**Consultation Response from Chris Bembridge KC,  
Highways Development Management**

**2023/91280 Bromley Farm Quarry, Barnsley Road, Upper Cumberworth, Huddersfield, HD8 8PD**

**Quarrying operations for the extraction of clay, shale and incidental coal and subsequent  
restoration by means of importation of inert wastes**

**Date Responded: 12/09/2024**

Project No. 22007	Dwg No. 22007/513	Rev B
Date: Aug 23	Drawn: PS	Chkd: MB
Scale: 1:2000 @ A3

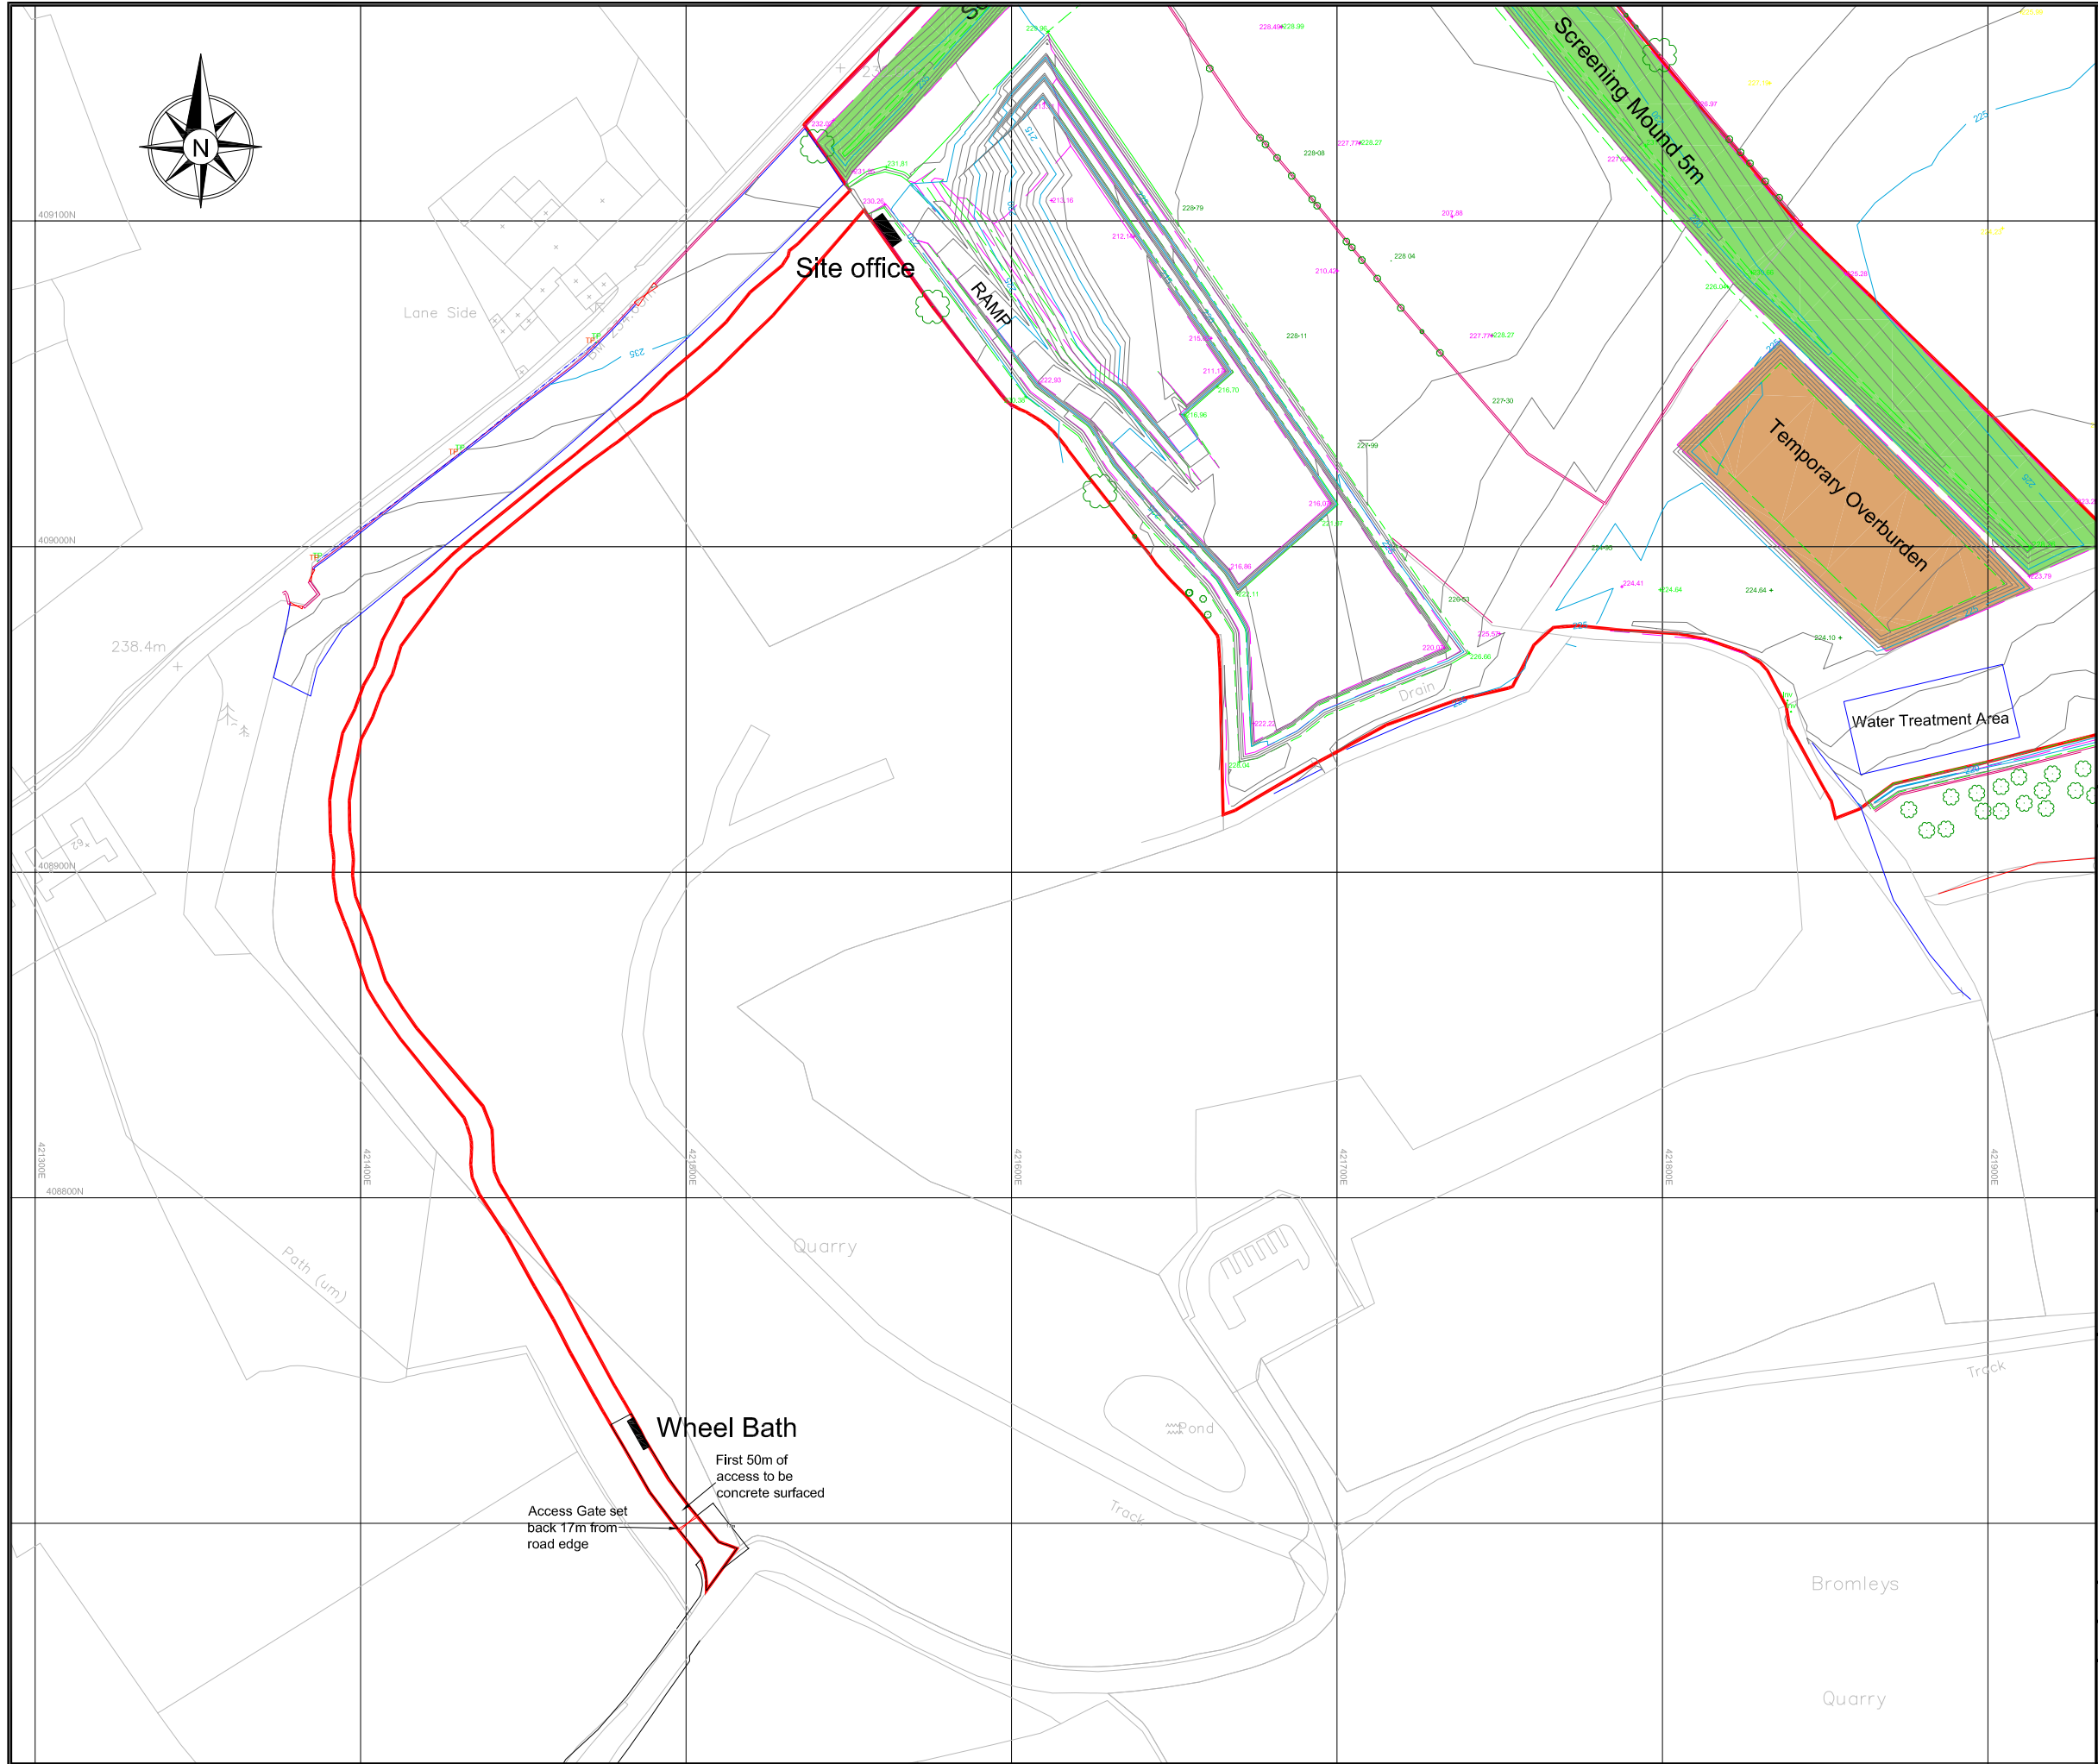
Drawing No 22007/513 indicates that the initial 50m of the internal site access road will be finished with a solid impermeable surface (concrete). This would form a solid join with the shared access road and would reduce the incidence of mud and debris being dragged on to the shared driveway in conjunction with suitable wheel washing facilities.

Details were also included on drawing No 22007/513 to indicate the location of the wheel washing facilities adjacent to the access point on the concrete apron, this is to avoid mud and quarry debris from

being dragged on to the shared driveway or even the adopted highway for highway safety reasons. The continued use of the wheel washing facilities should be conditioned to last for the lifetime of the development, including infill.
